RFI

RFI #: 212
Date: 11/27/2012
Job: EB-02 Keller Springs Lofts
Phone: 877-777-5115

Subject: details and clarification needed for planters at club/leasing entry

SHEET
 2C OF 9

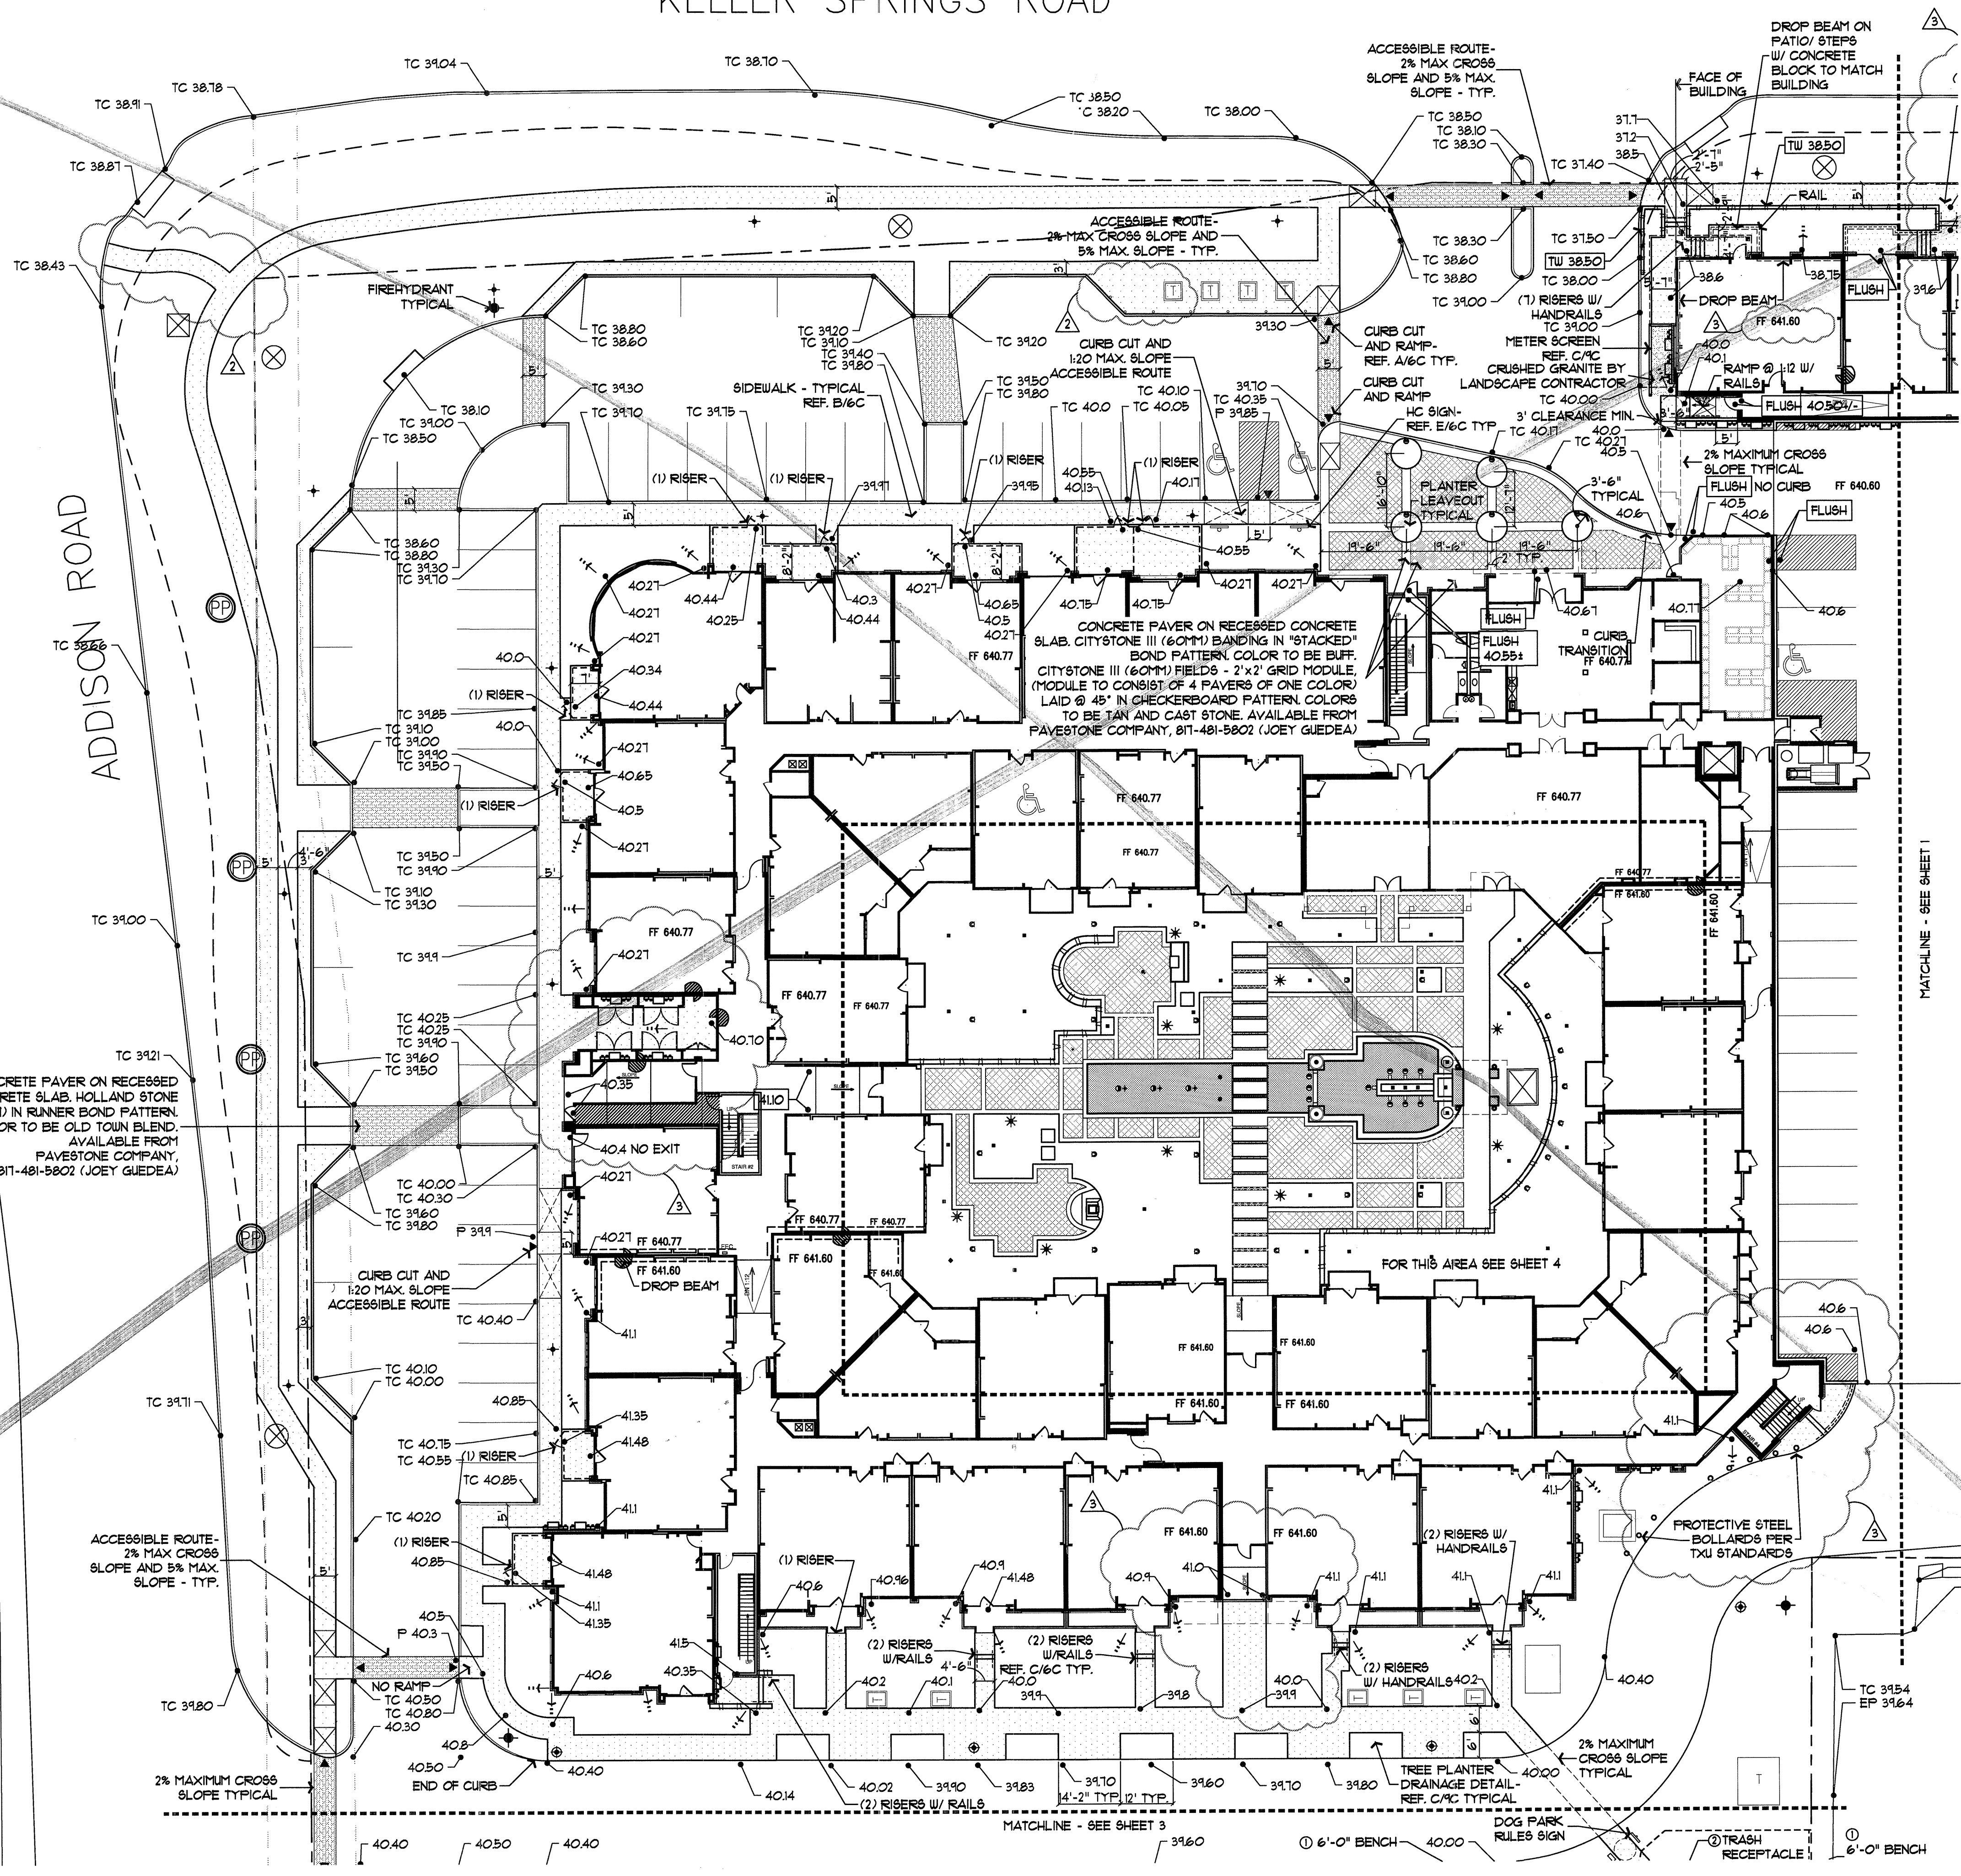
Request: Outside the club/leasing entry there is an area of brick pavers with 5 planter areas which are labeled planter leave out typical. As shown on 2C it looks like these areas are 7" in diameter and have drip tubing and a single 4" pop out lawn head in each of them. Can we get a clear detail showing these planter areas including how the pavers are laid to form the planter circles? Also, I assume there are no drains in these planters. How far recessed is the planter bed from the top of the pavers? Please give details for clarification.
Date Required: 12/4/2012

Response:
After discussions with David Gallagher and Brian Peterson, we have decided to go ahead and recommend a 4" width curb around the perimeter of the leaveouts. The curb is to be finished and flush with the top of pavers. The pavers are to be cut accordingly to butt up against the 4" curb. Typical dirt finish grade in planting leave out is 1.5" below top of paver. Set drain inlet elevation accordingly. Reference irrigation drawings for irrigation info for each of the leaveouts. A drain is to be included within each of the leaveouts. We propose (1) 6" round brass grate and (1) 6" round spee-d basin for each of the leaveouts from NDS pro. 800-726-1994. (ndspro.com) please let us know if you need our drawings to be updated to reflect this change.

Request: We have a continuing problem occurring almost daily with tractor trailers jumping the curb and rutting up the sod at the corner of Addison Rd. and Keller Springs Rd. We asked to city if we could place large boulders in this area and they declined. We talked about installing sub base and river rock with edging and they were agreeable. Landscaper would have to adjust his irrigation sprinklers so the area is kept dry. Please advise.
Date Required: 5/10/2013

Response:
We think the sub base with river rock will be a practical solution. However, please see the attached PDF. Would it be possible to make the river rock bed a little more organic in design? We feel it will make the bed of river rock look more like it was part of the design rather than just an afterthought to keep the corner from getting torn up from the trucks. It does not have to be this exact design or size as you will have a better idea in the field of just how big the bed needs to be to protect the corner. Adjust irrigation in field as needed.
